**Application No: 20/01575/FULL – site 363 Ings Rd, HU7 4UY**

We are writing to object to the above proposal for the erection of a single storey garage/outbuilding.

EAST & WEST ELEVATIONS AS PROPOSED SCALE: 1:50 @ A2 DECEMBER 2020 DRAWN: J W DRAWING NO:2465/P4/REV B

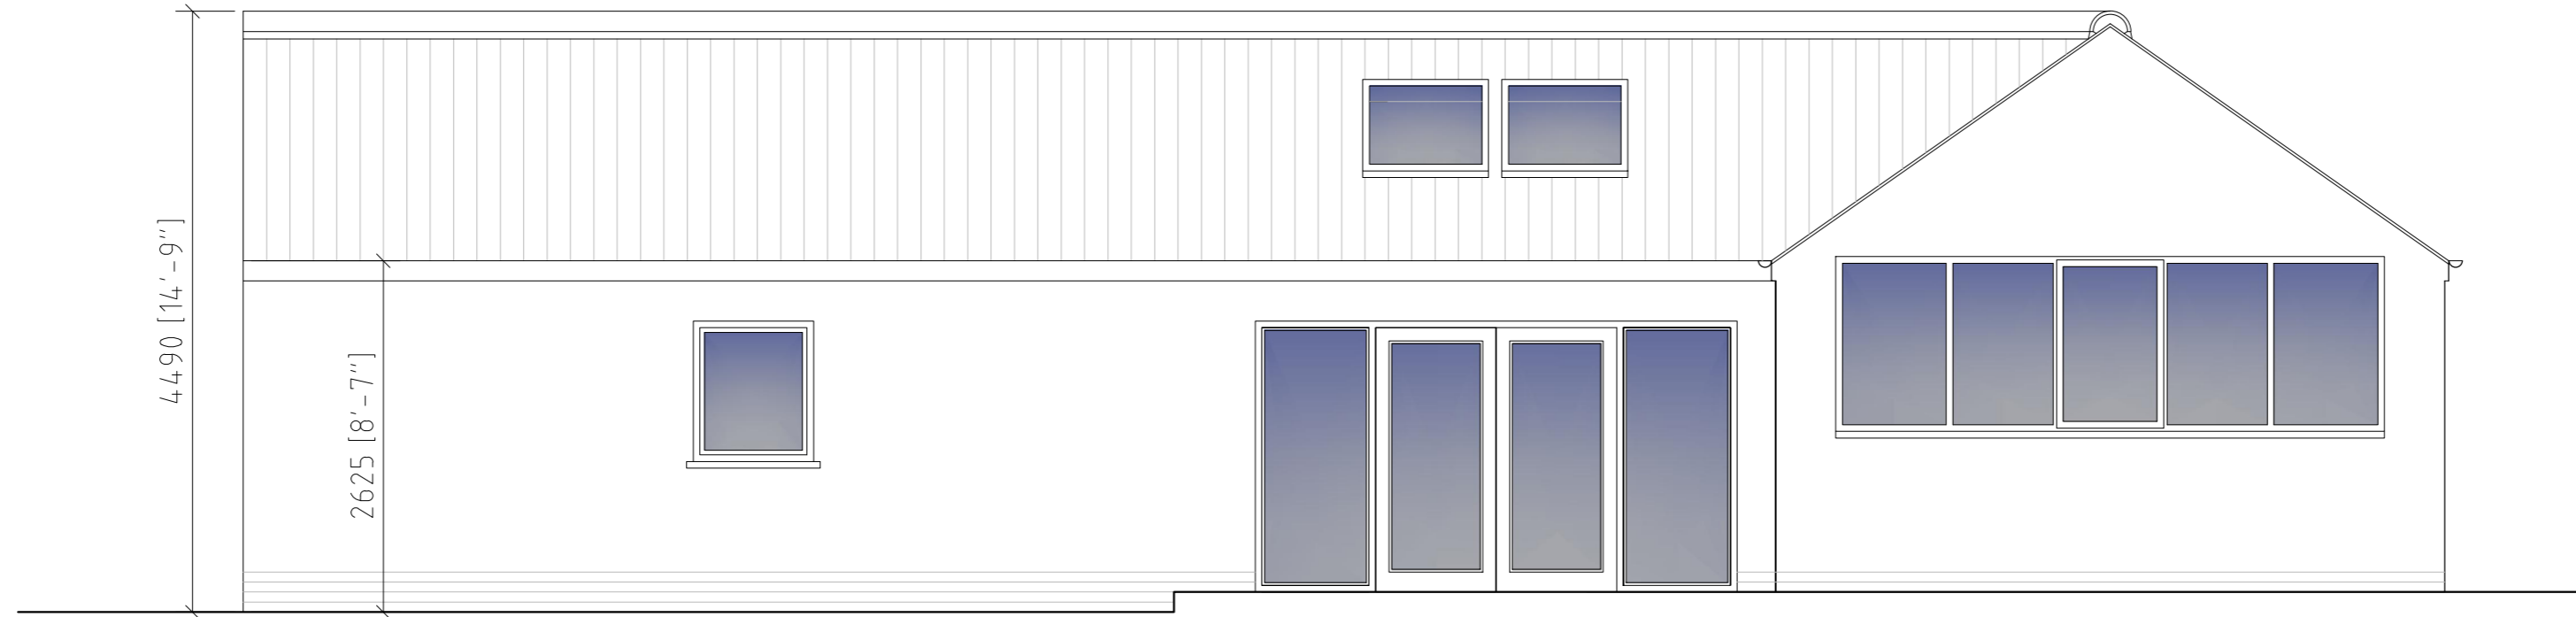
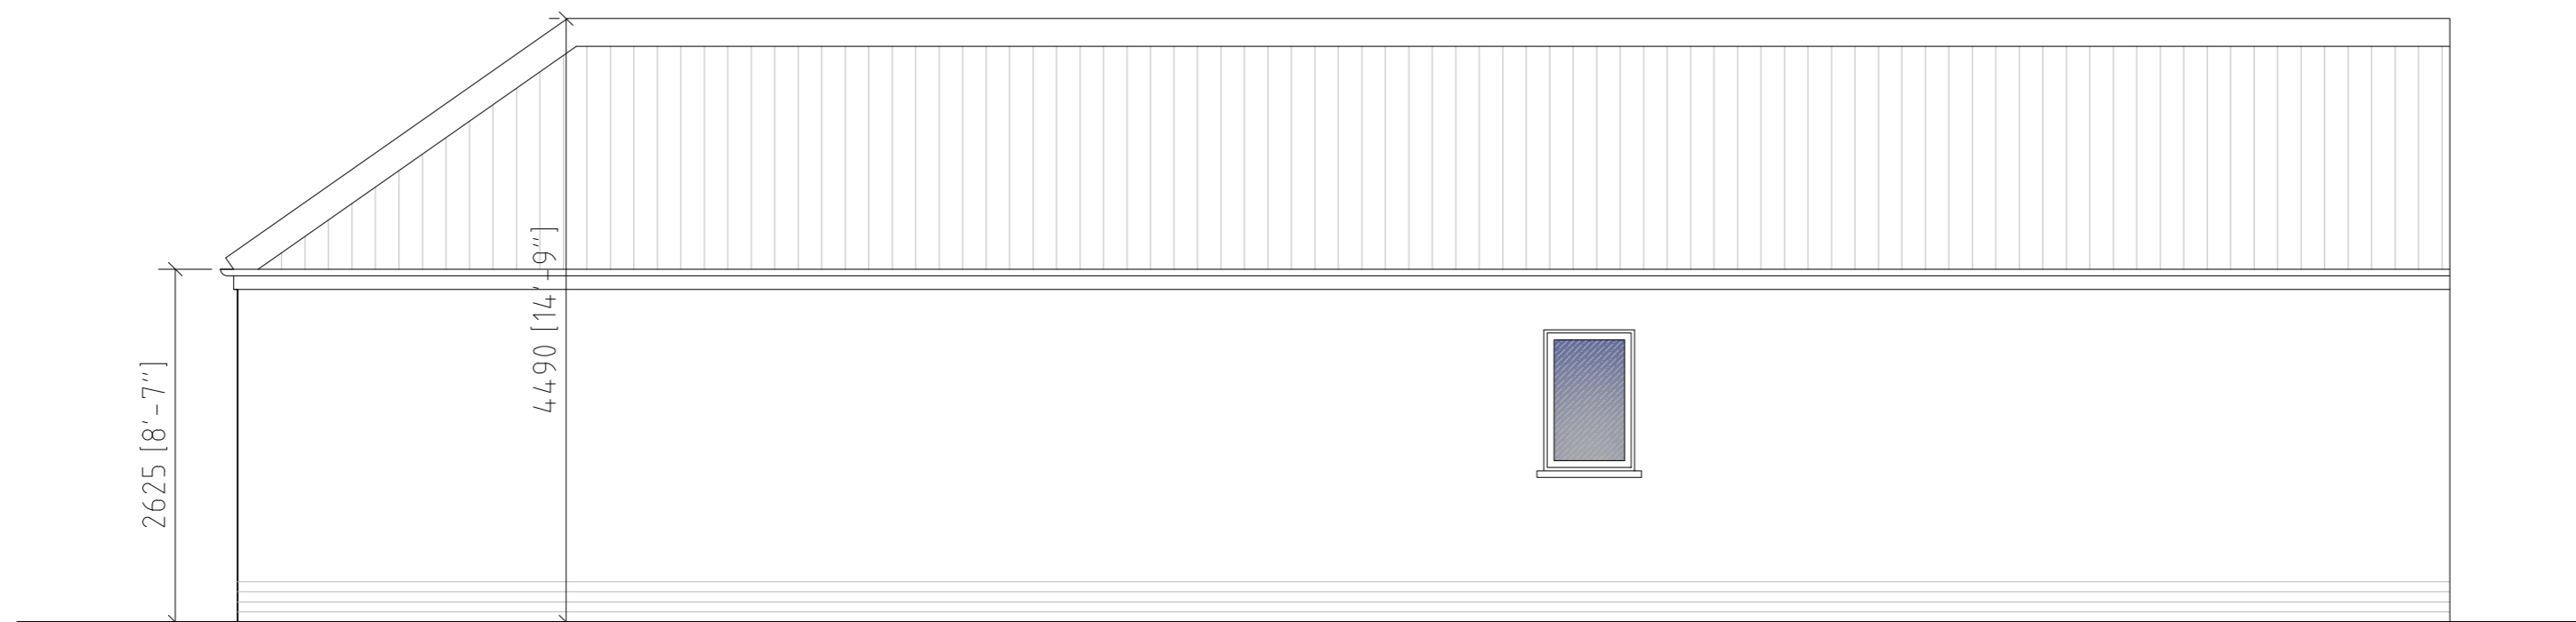
The length of the proposed building would cover the entire back of my garden, along with another 3 of my neighbours, and being of the great height proposed would severely affect our views, being that we would be staring at a brick wall and massive roof blocking all of our natural daylight, and also any sunlight. Other concerns would be the associated noise pollution that the use of this building would create, and whilst we accept noise will be around us as we are in family surroundings, this would be presumably be made far worse and more regular with such a building of this scale.

The building would dominate the view in our back garden and make us feel boxed in, being far too overbearing.

A flat roof could be a compromise which we may consider as in our opinion this would still meet the needs and purpose for the proposed building without having such detrimental effects on mine and other neighbouring properties.

SECTION A-A AS PROPOSED

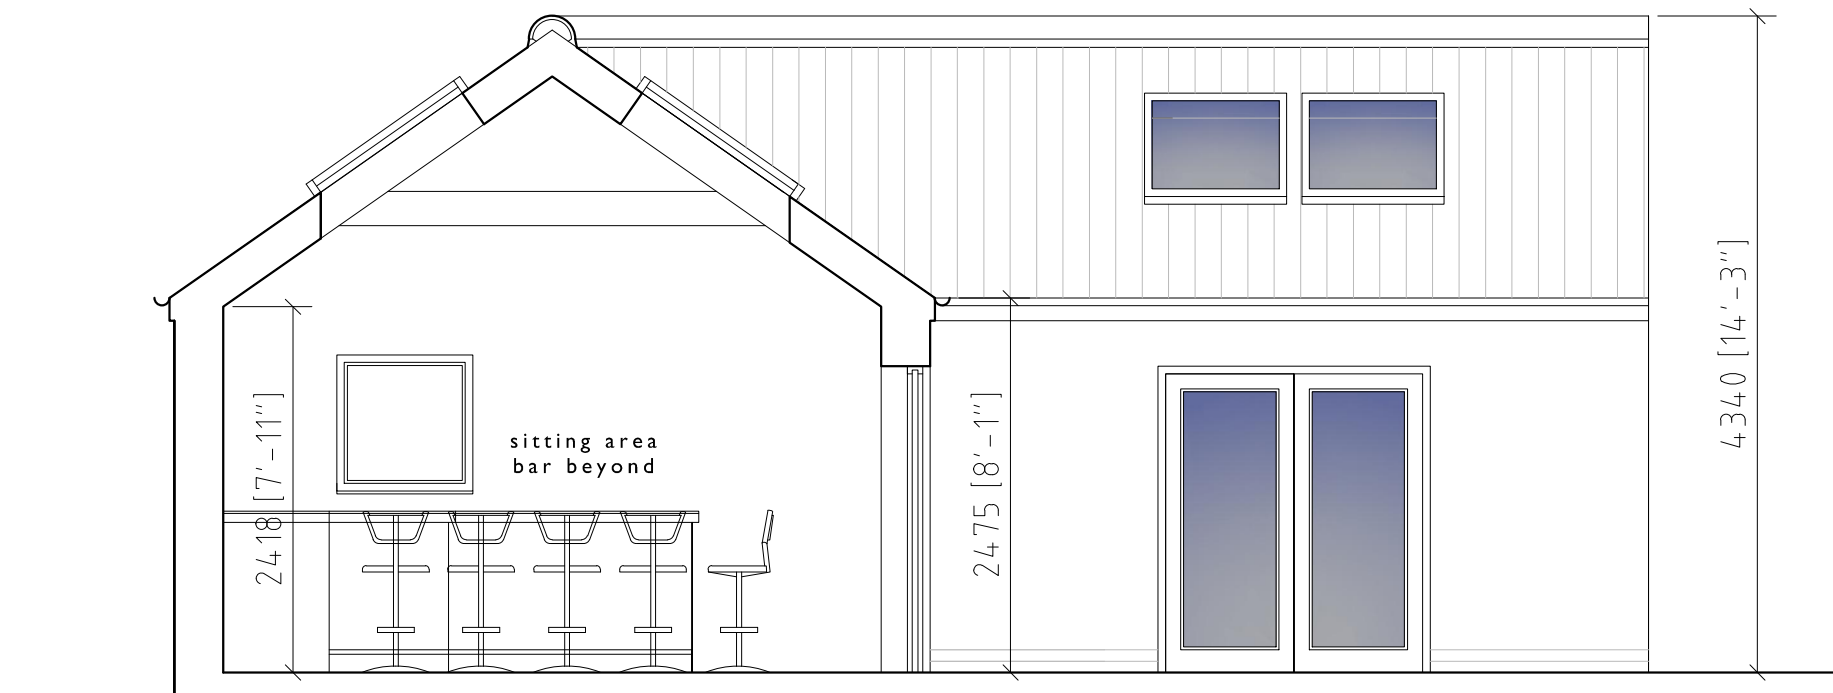
The height of the roof alone, 4.49m would mean that my garden would be totally blocked off from any direct light and no doubt any neighbouring properties would be too. A garage/outbuilding would surely not warrant a roof of this enormous size? Given that the proposer's land is higher than ours to start with, this would mean the building being even higher still on my side.
